Civil Engineering Impacts on Existing Tree Cover

**Hammond Ground, Read in respect of
Application No. 3/2026/0356**

**For the erection of 77 no. dwellings and creation of
community parkland with vehicular access from Whalley
Road and associated infrastructure, parking and landscaping**

Technical Working Notes – Earthworks, Trees and Enabling Works

Job Number	Originator	Zone	Level	Type	Role	Drawing No.	Rev
24024	PWA	00	XX	DR	C	2000	P01

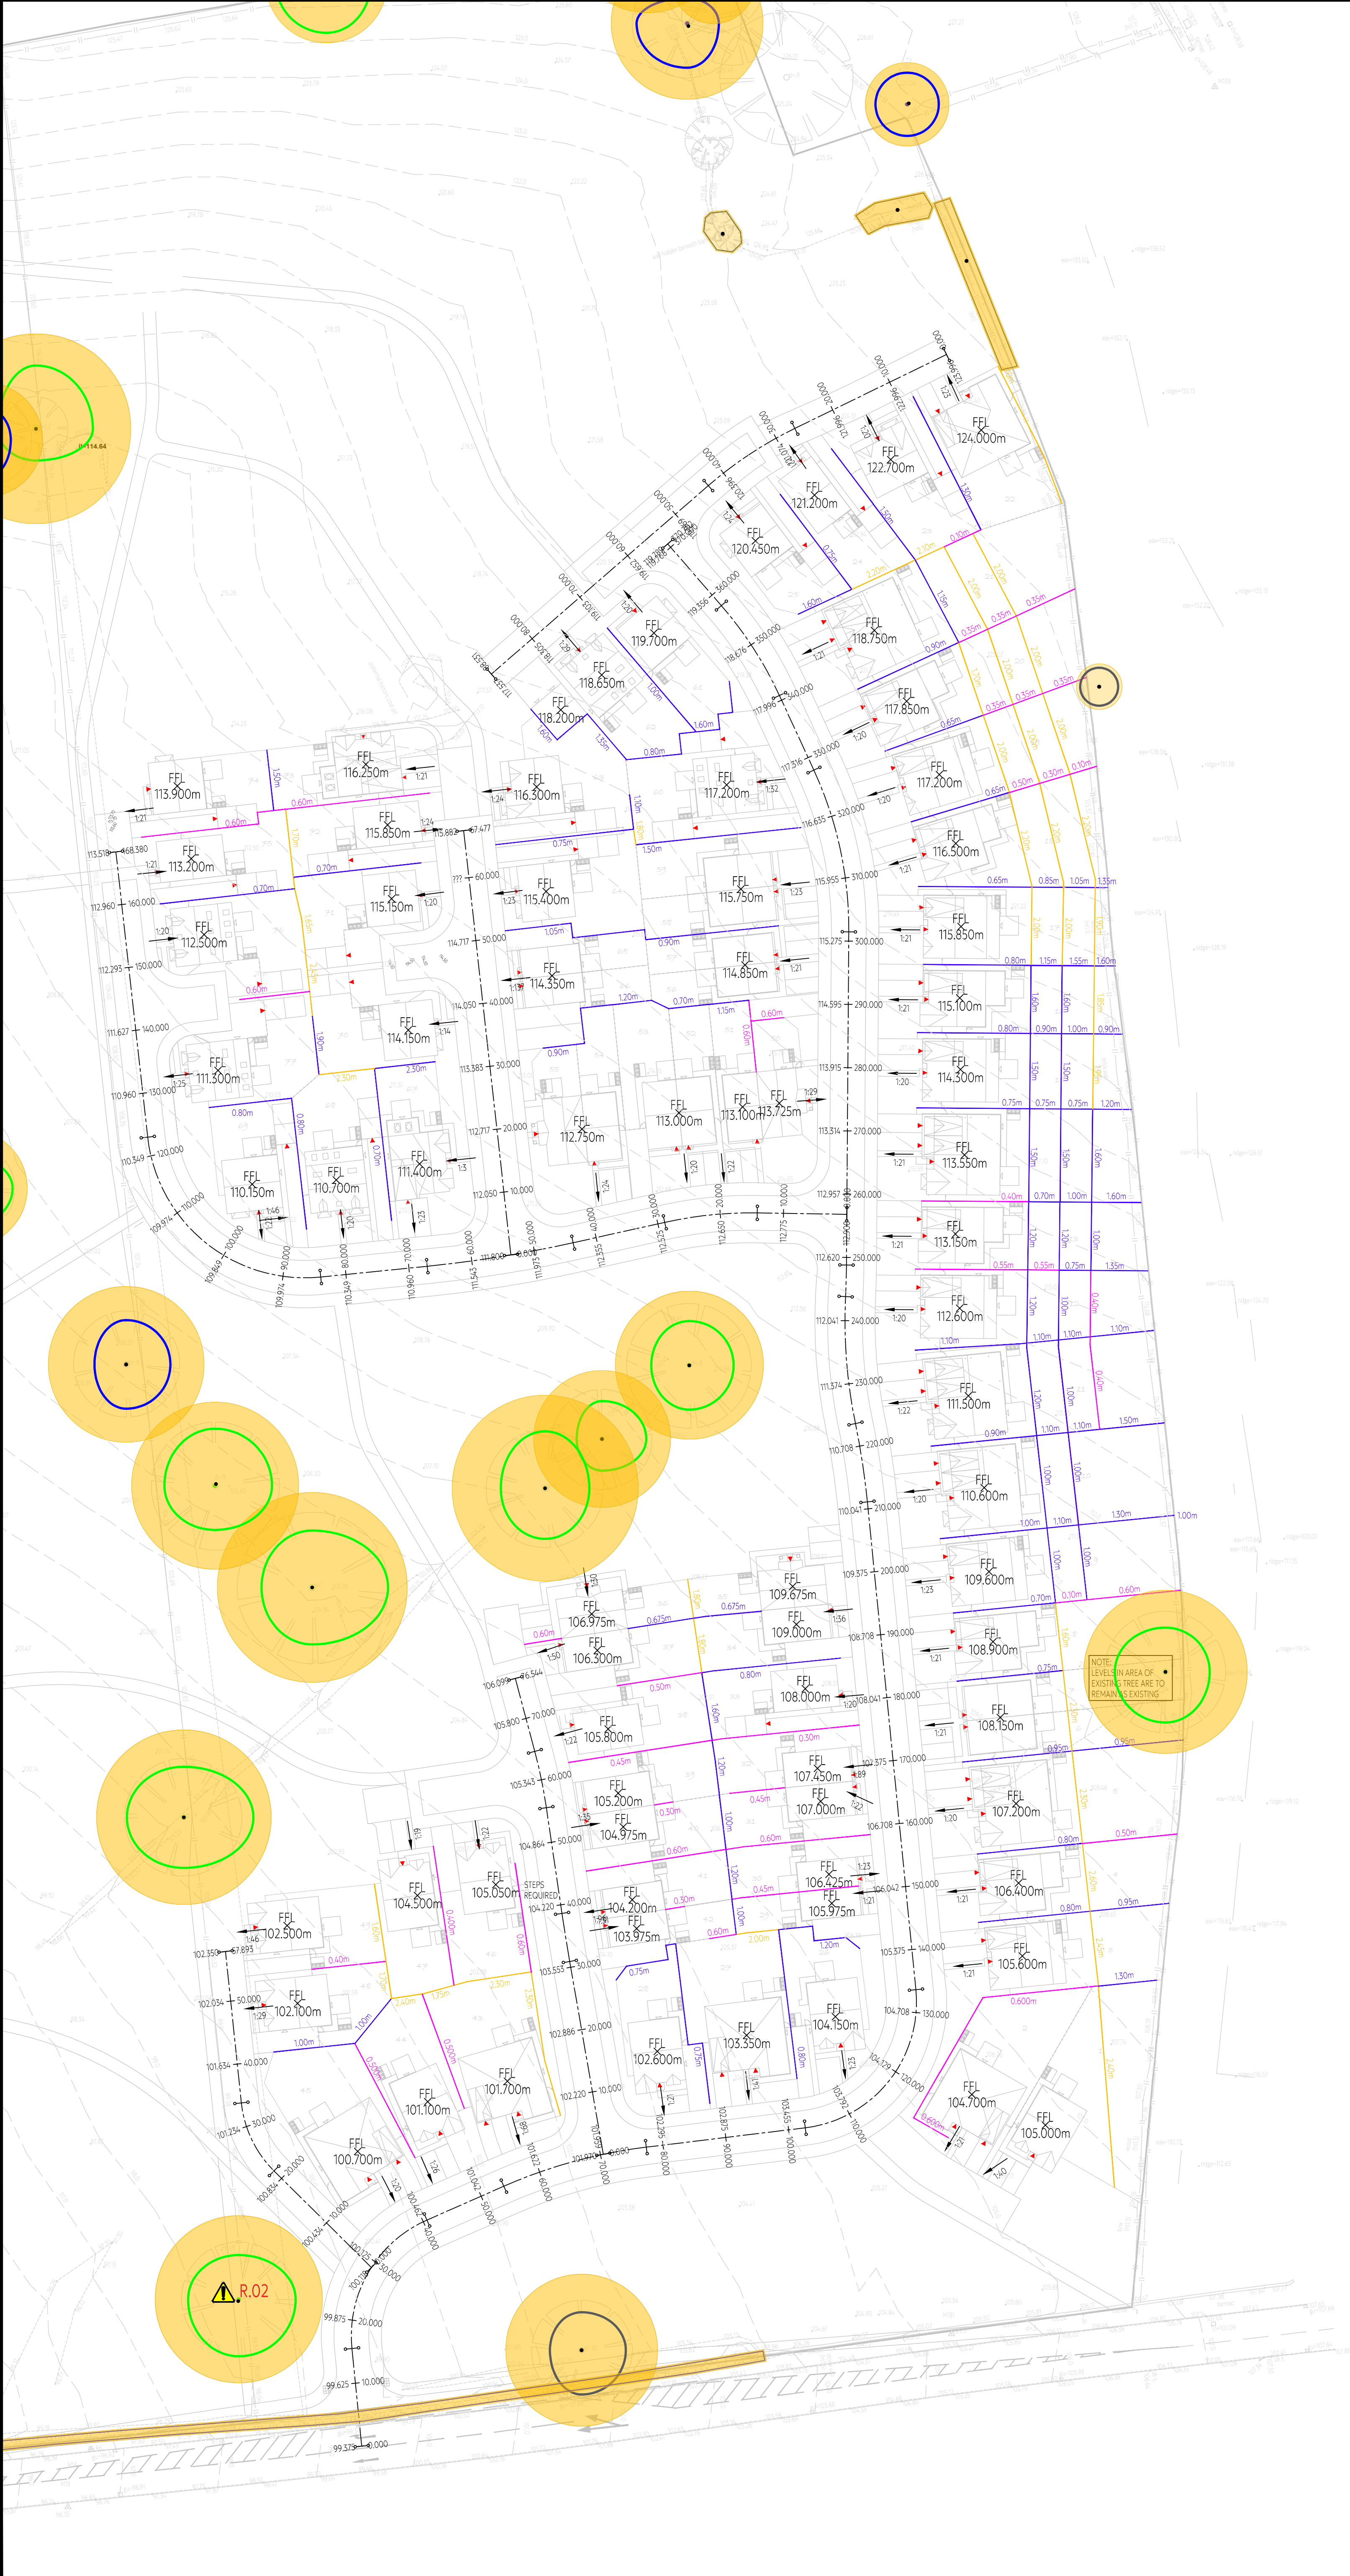
- The External Works drawings identify retained mature trees and Root Protection Areas within or adjacent to areas where significant engineering works are proposed.

- The drawings also contain notes stating that existing levels around certain retained trees are to remain unchanged, together with references highlighting the need for arboricultural consideration. This suggests the relationship between the proposed earthworks and retained trees has already been recognised as a design constraint.

- From reviewing the submitted information, I cannot reconcile how some of the proposed regrading, highways and retaining structures can be carried out whilst maintaining the existing ground levels required to protect a number of the retained trees.

- The proposed highway junction appears to be located immediately adjacent to the retained mature trees, with parts of the proposed road and footpath extending into, or immediately alongside, the Root Protection Areas shown on the submitted drawings.

- The Root Protection Area also extends beneath the existing hedge line, yet the proposed junction appears to require the removal of part of the existing boundary and hedge to accommodate the revised highway layout and required visibility splays.

- From reviewing the submitted drawings, I have been unable to identify how these engineering works can be undertaken whilst maintaining the Root Protection Areas and protecting the retained trees throughout construction.

- This retained mature tree appears to remain within an area where substantial regrading of the site is proposed.
- The surrounding drawings indicate retaining walls, changes in finished levels and significant earthworks immediately around the tree.
- Before retaining walls and final levels can be constructed, it is likely that bulk earthworks would first be required to establish the new development platforms.
- From reviewing the submitted information, I cannot understand how those bulk earthworks could be undertaken whilst preserving the existing ground conditions around the retained tree.

- The Designers Risk Assessment identifies **Risk Reference R.02** relating specifically to the existing retained tree.
- The risk assessment states:
 - *"Levels within TPO are lower than the existing road. It is suggested that an arboriculturist is consulted."*
- This indicates that the design team has already recognised that the relationship between the existing tree, surrounding levels and the proposed engineering works requires further consideration.
- However, from reviewing the submitted drawings, it remains unclear how the proposed level changes and associated construction works will be carried out whilst protecting the retained tree and its Root Protection Area.
- The submitted information would benefit from further explanation demonstrating how the engineering proposals and tree protection measures are intended to work together throughout construction.

The designers have identified this tree as a design risk. What engineering and arboricultural measures are proposed to address that risk whilst delivering the proposed level changes?
